# TIERRA WEST, LLC

**RE: GLOBAL STORAGE TIS - 3421 COORS BLVD NW  
TRAFFIC IMPACT STUDY- RESPONSE TO COMMENT**

1 SITE PLAN - MAJOR AMENDMENT
AS.1
1" = 30'-0"

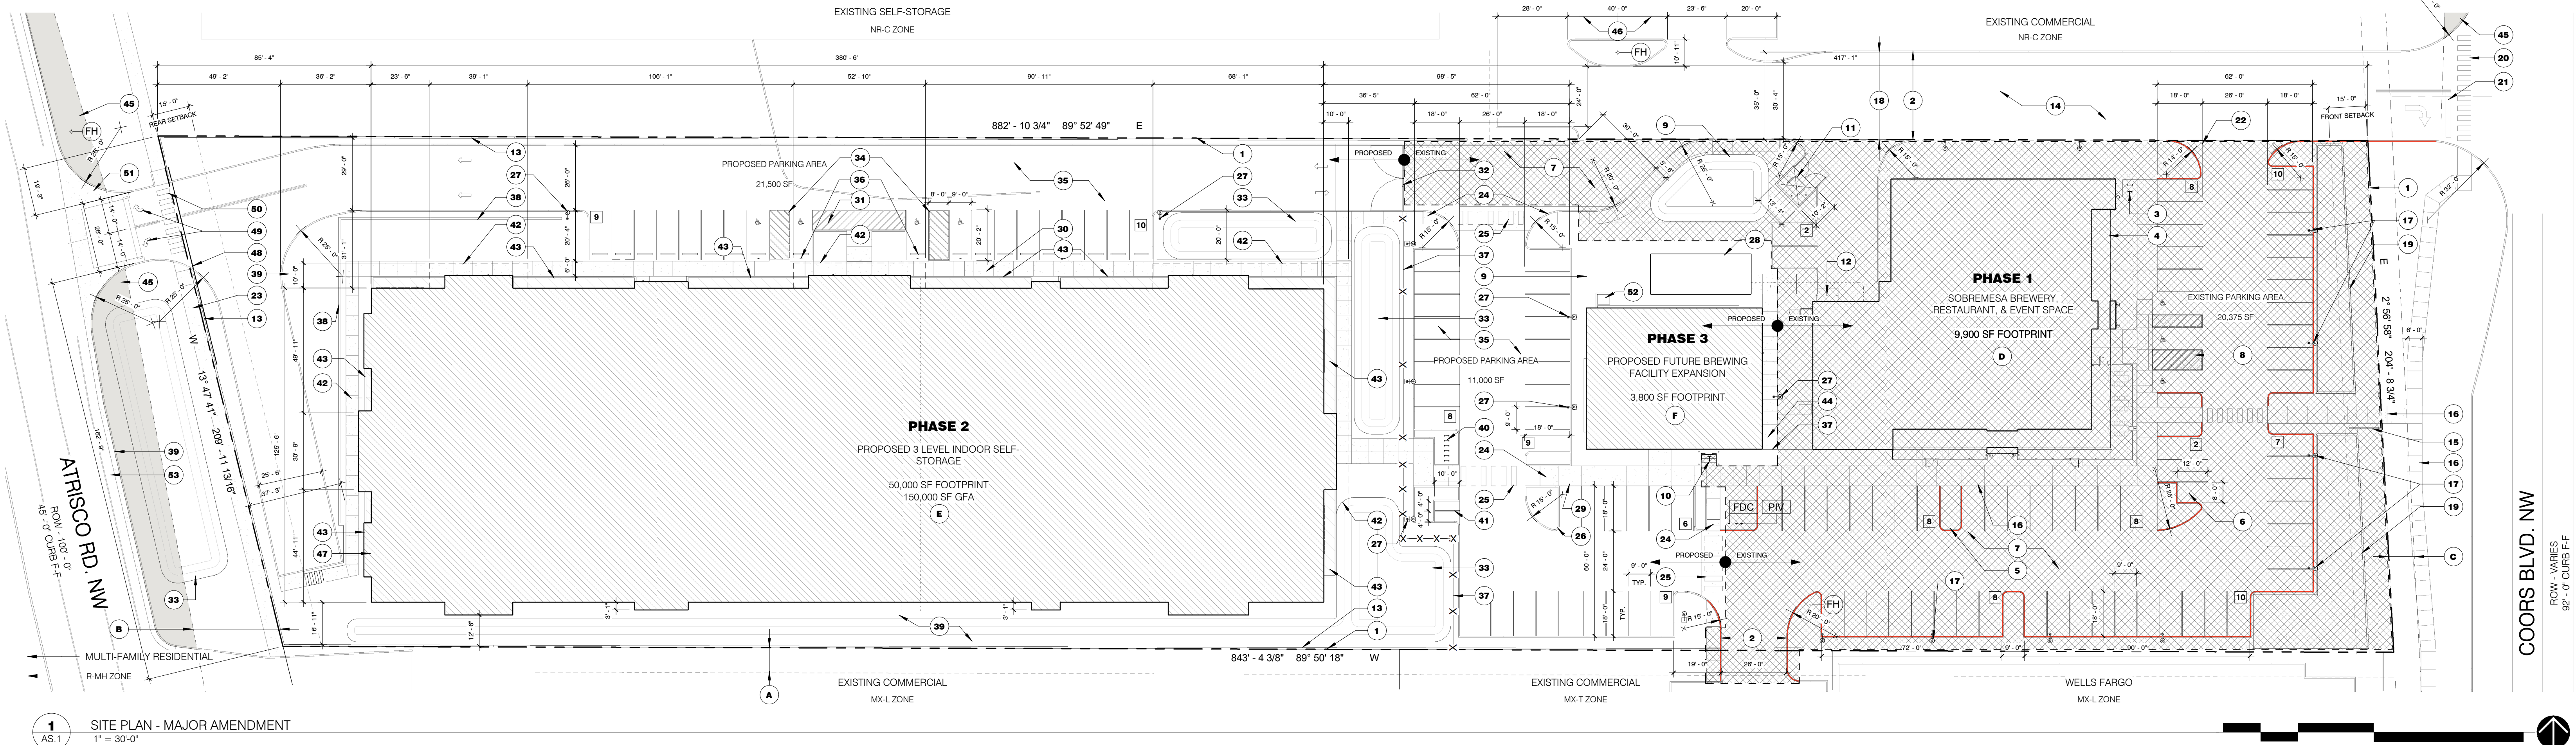
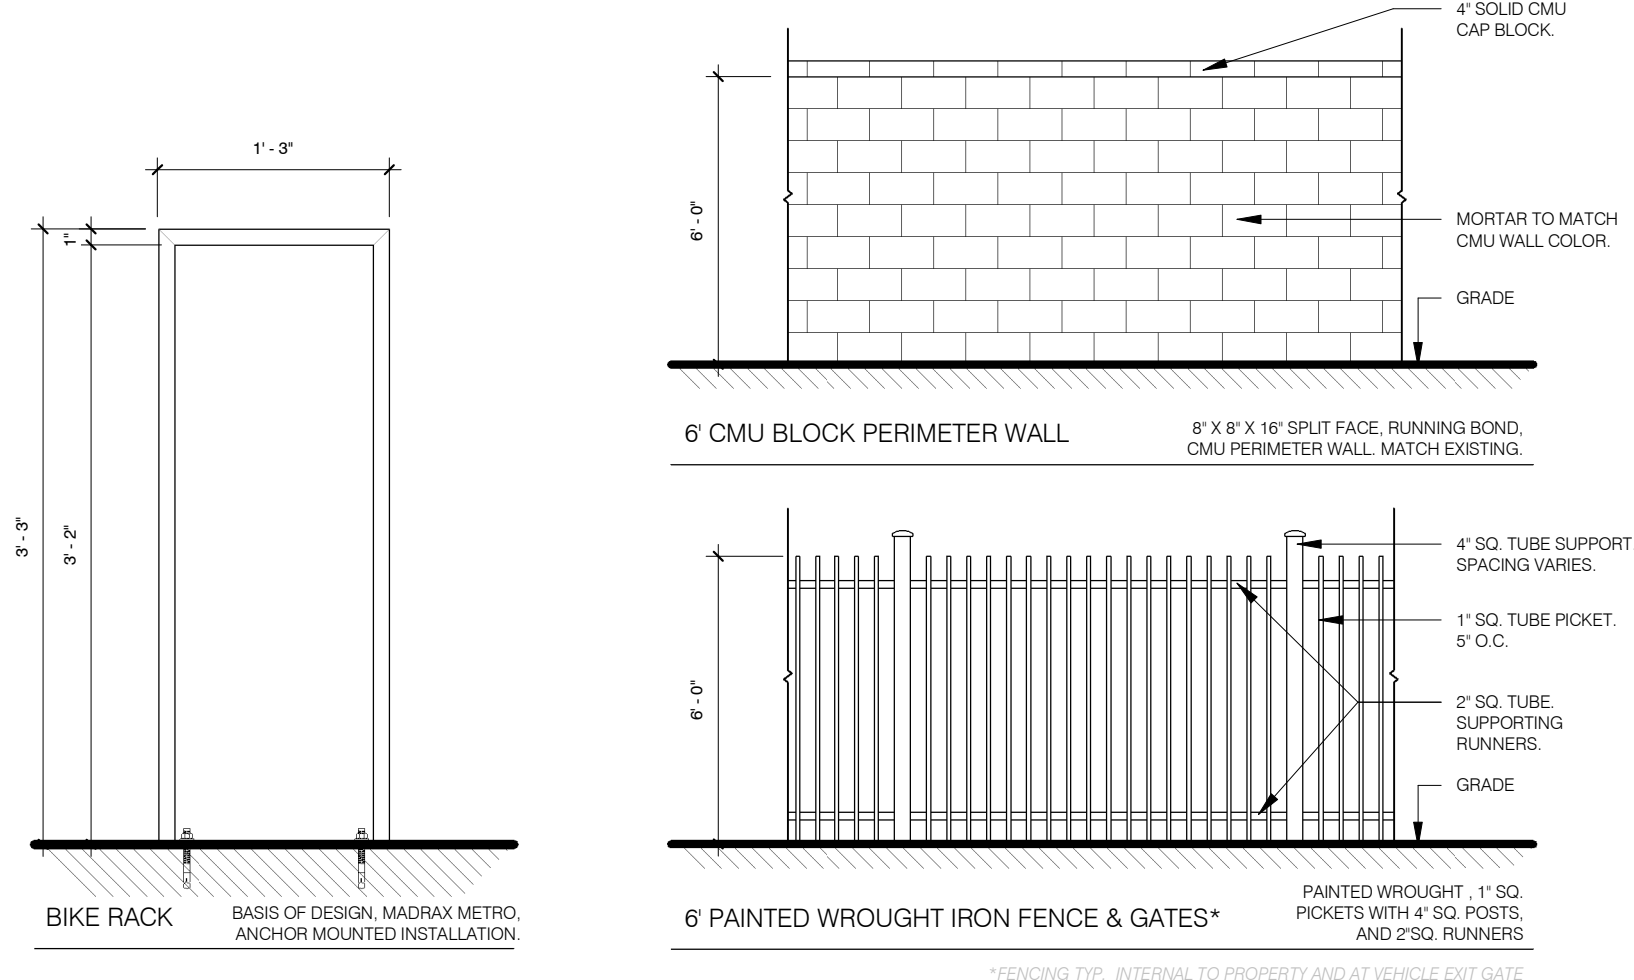
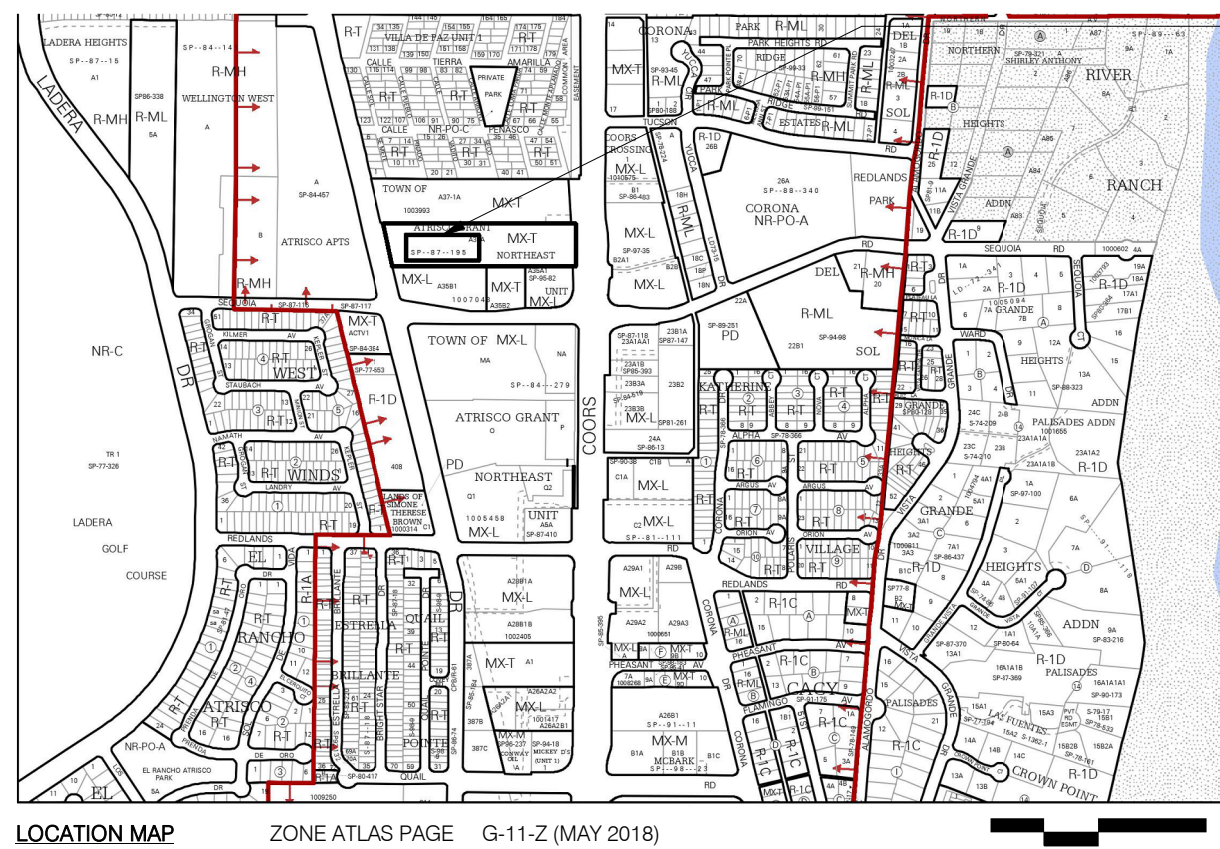
1. Describe the restricted access between the storage area and the restaurant/proposed brew pub.  
**RESPONSE: The restricted access will consist of a new 28ft swinging vehicular access gate with FDC access override. The parking area for the restaurant/proposed brew pub can still be accessed from the shared access Driveway "A" as well as Driveway "B."**
2. The driveway on Atrisco Dr. is gated. Describe the access and show the pavement marking arrows on the site plan. Move the driveway dimension line on the site plan to be where the driveway is.  
**RESPONSE: The access at the driveway located on Atrisco Dr. will be an exit only for the Global Storage Development. The pavement markings have been added to the Site Plan. See attached.**
